Please see comments below from Private Sector Housing;

APPLICATION NO: BR/34/20/PL

Site Address: 102 Linden Road Bognor Regis PO21 2BD

Description of Works: Change of use from 1 No. detached house (6 bedrooms) to 2 No. semi detached houses (1 x 5 bedroom & 1 x 3 bedroom) with a single storey rear extension.

PROPOSED CONVERSION TO
TWO DWELLINGS

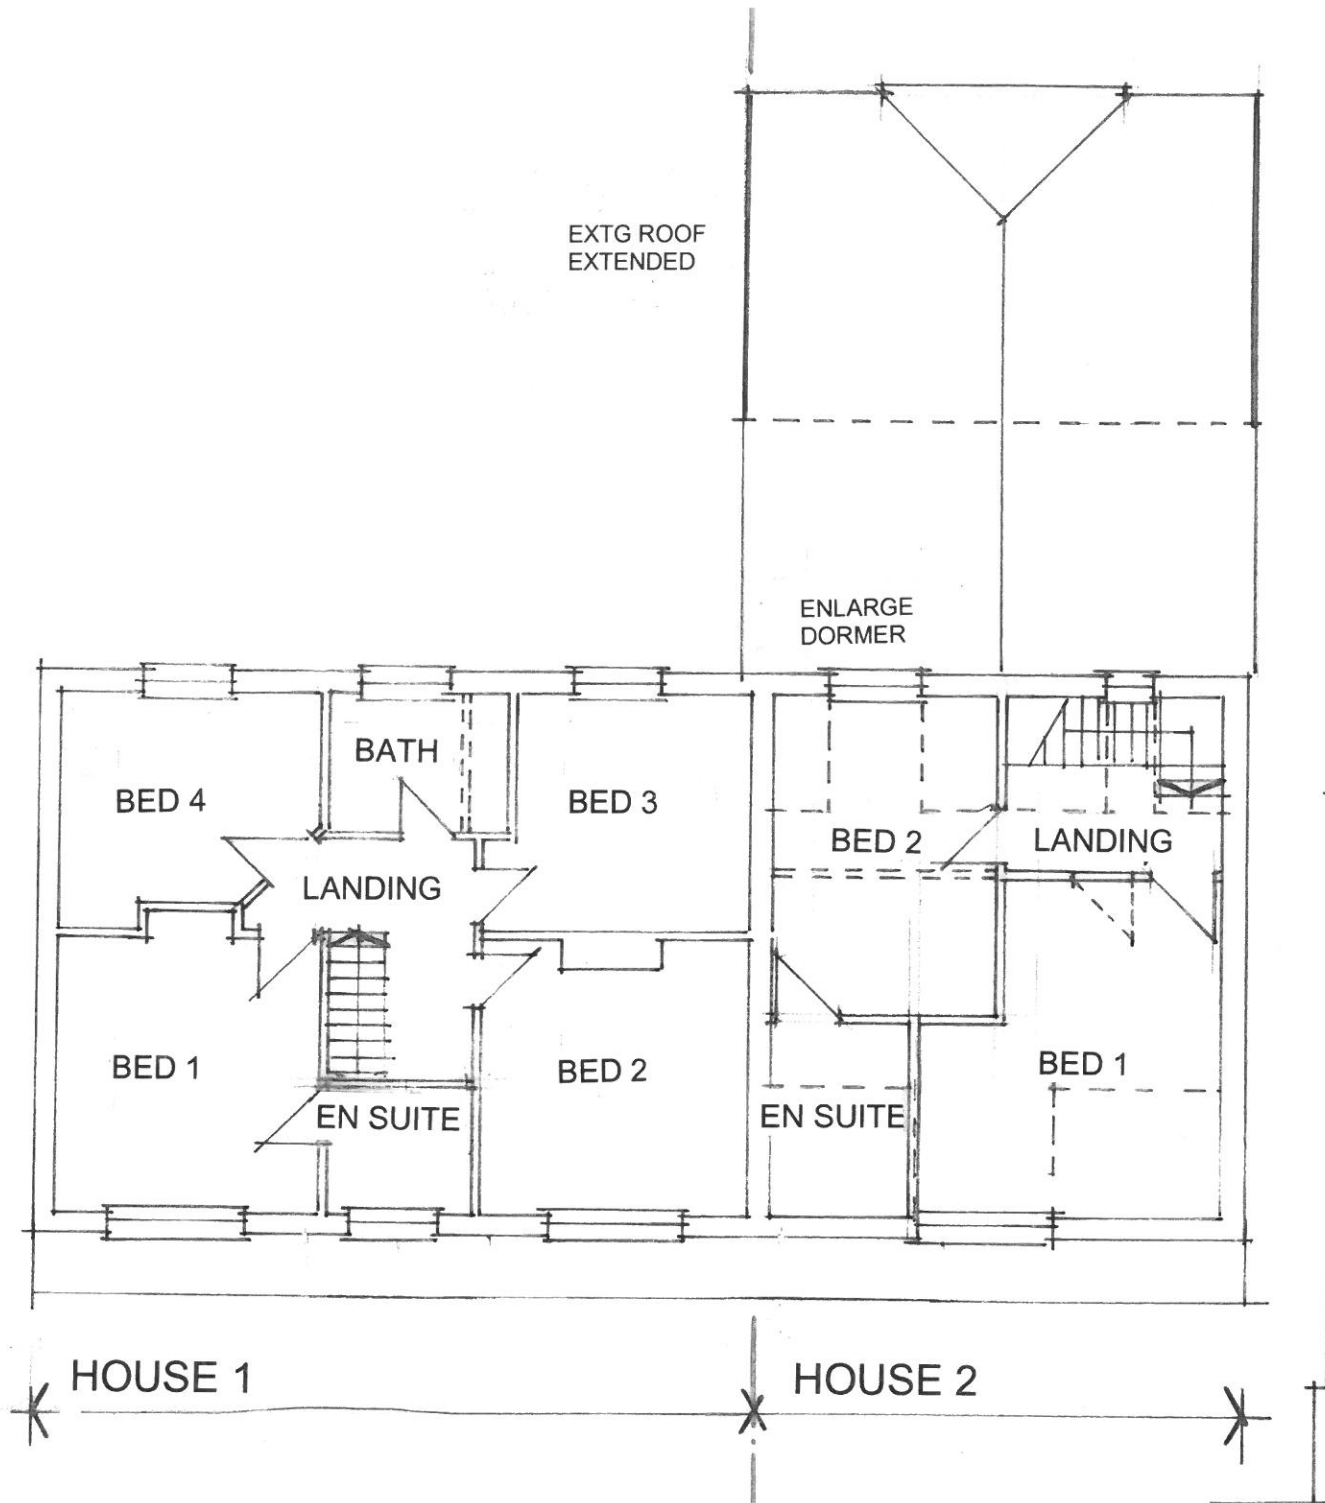
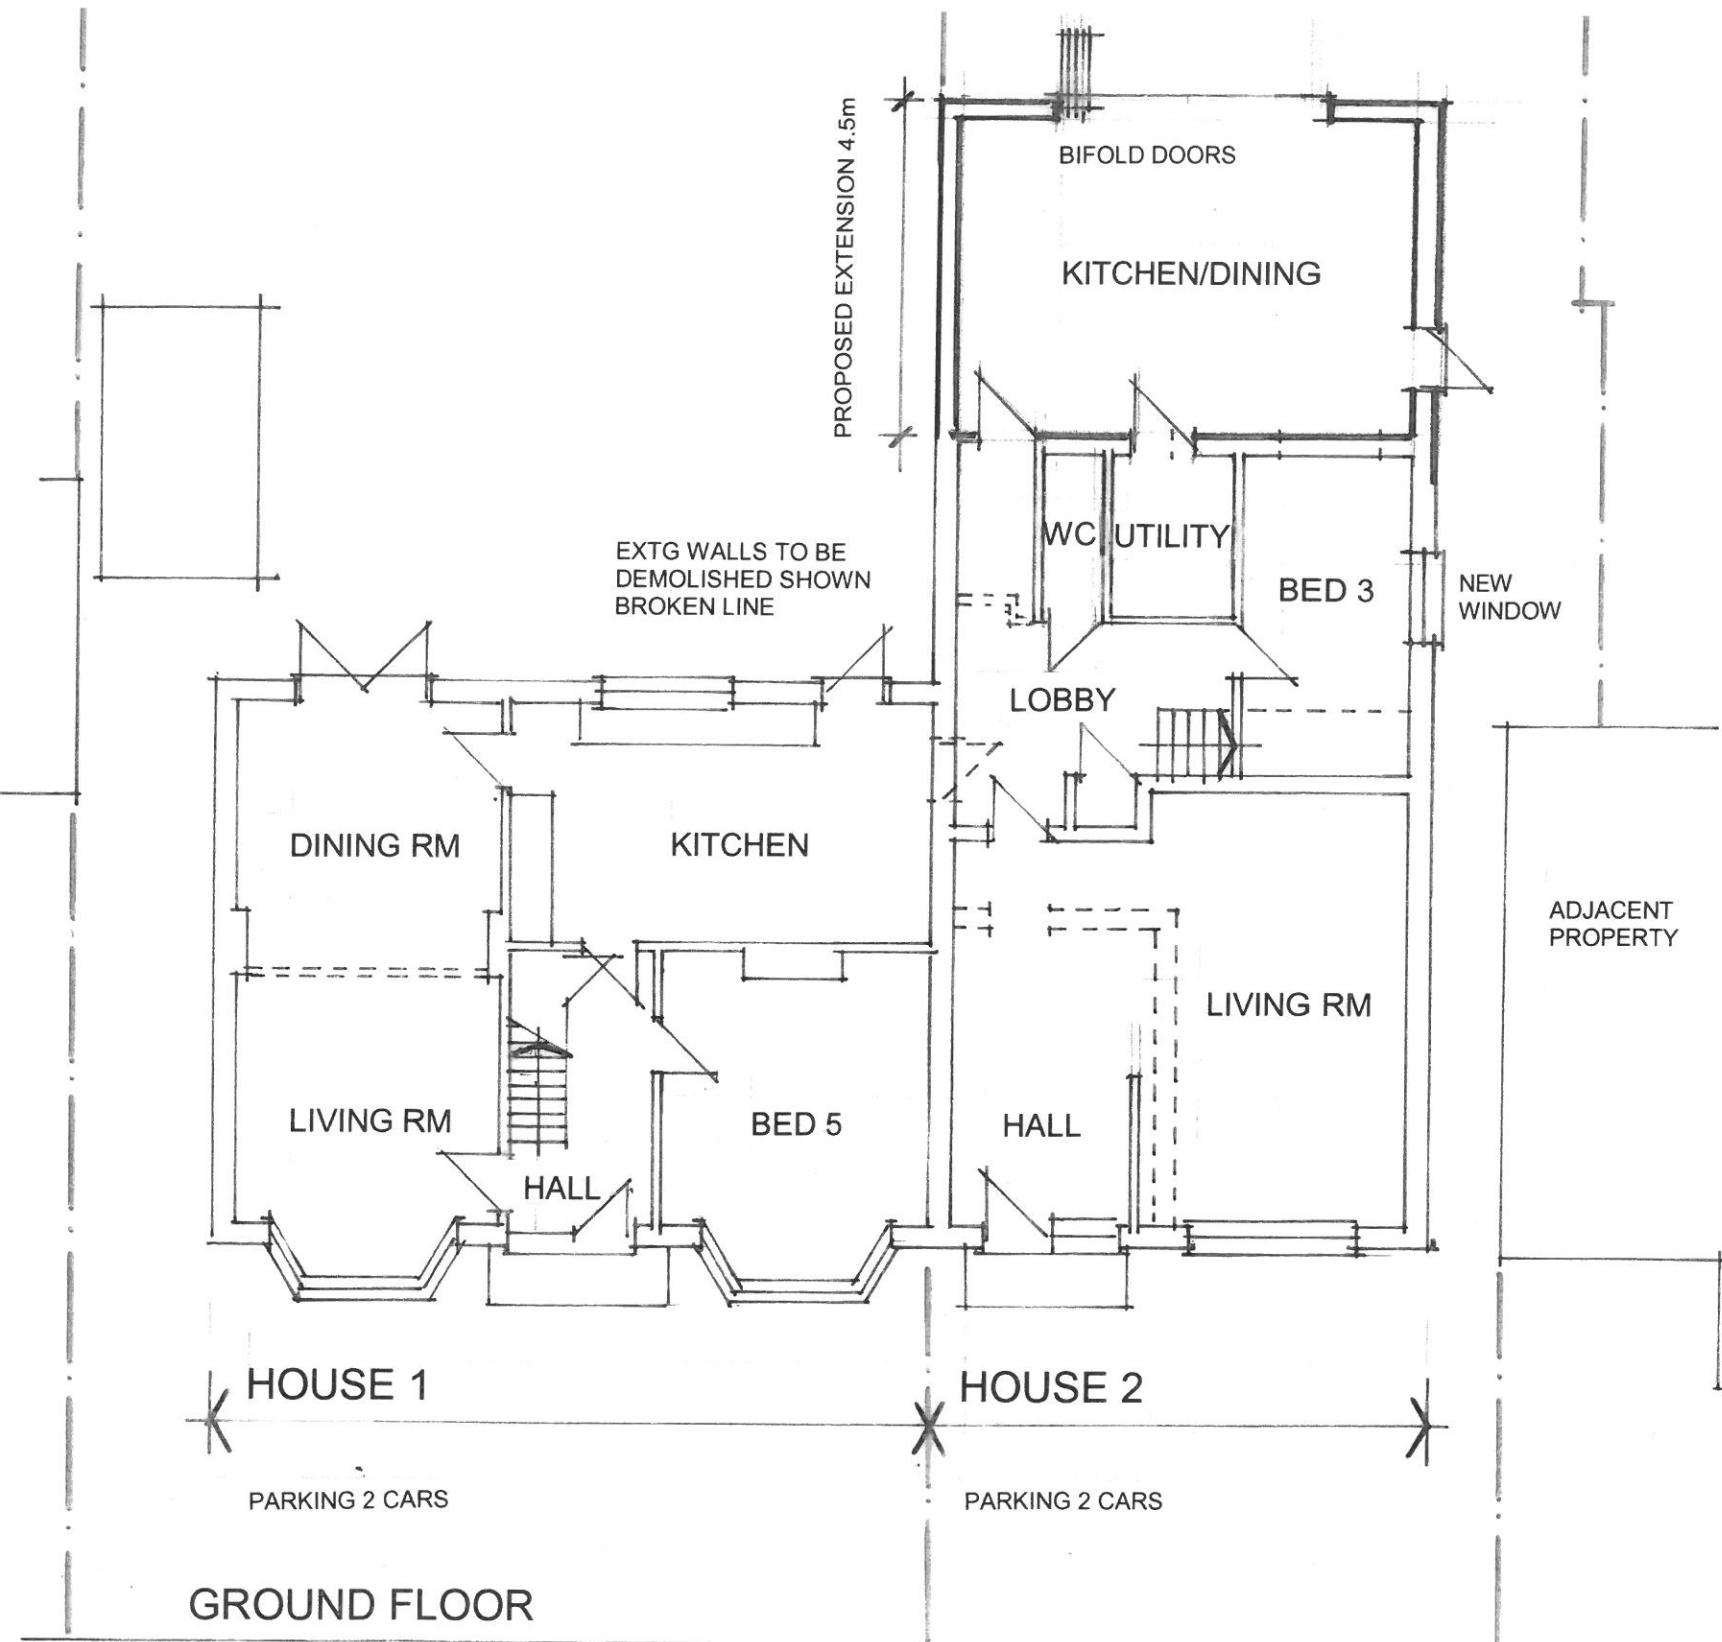
- If one or both properties is to be rented: Grade D1, LD2 system;
Install and maintain a Grade D1, LD 2 fire alarm system comprising interlinked mains wired smoke alarms with tamper-proof integral battery back-up located along the escape routes, to the cupboard under the stairs in ‘house 1’ if the cupboard is housing any electrics and to the utility room in ‘house 2’ if high risk items such as a washing machine will be present, and an interlinked mains wired heat detector with tamper-proof integral battery back-up located in the kitchens

- If one property is owner-occupied: Grade D2, LD2 system;
Install and maintain a Grade D2, LD 2 fire alarm system comprising interlinked mains wired smoke alarms with user-replaceable integral battery back-up located along the escape routes, to the cupboard under the stairs in ‘house 1’ if the cupboard is housing any electrics and to the utility room in ‘house 2’ if high risk items such as a washing machine will be present, and an interlinked mains wired heat detector with user-replaceable integral battery back-up located in the kitchens

- There appears to be no bathroom within ‘house 2’

- Mechanical extraction should be provided to all bathrooms/shower rooms/en suites
- As there is no openable window casement to the separate WC within ‘house 2’, mechanical extraction should be provided here also
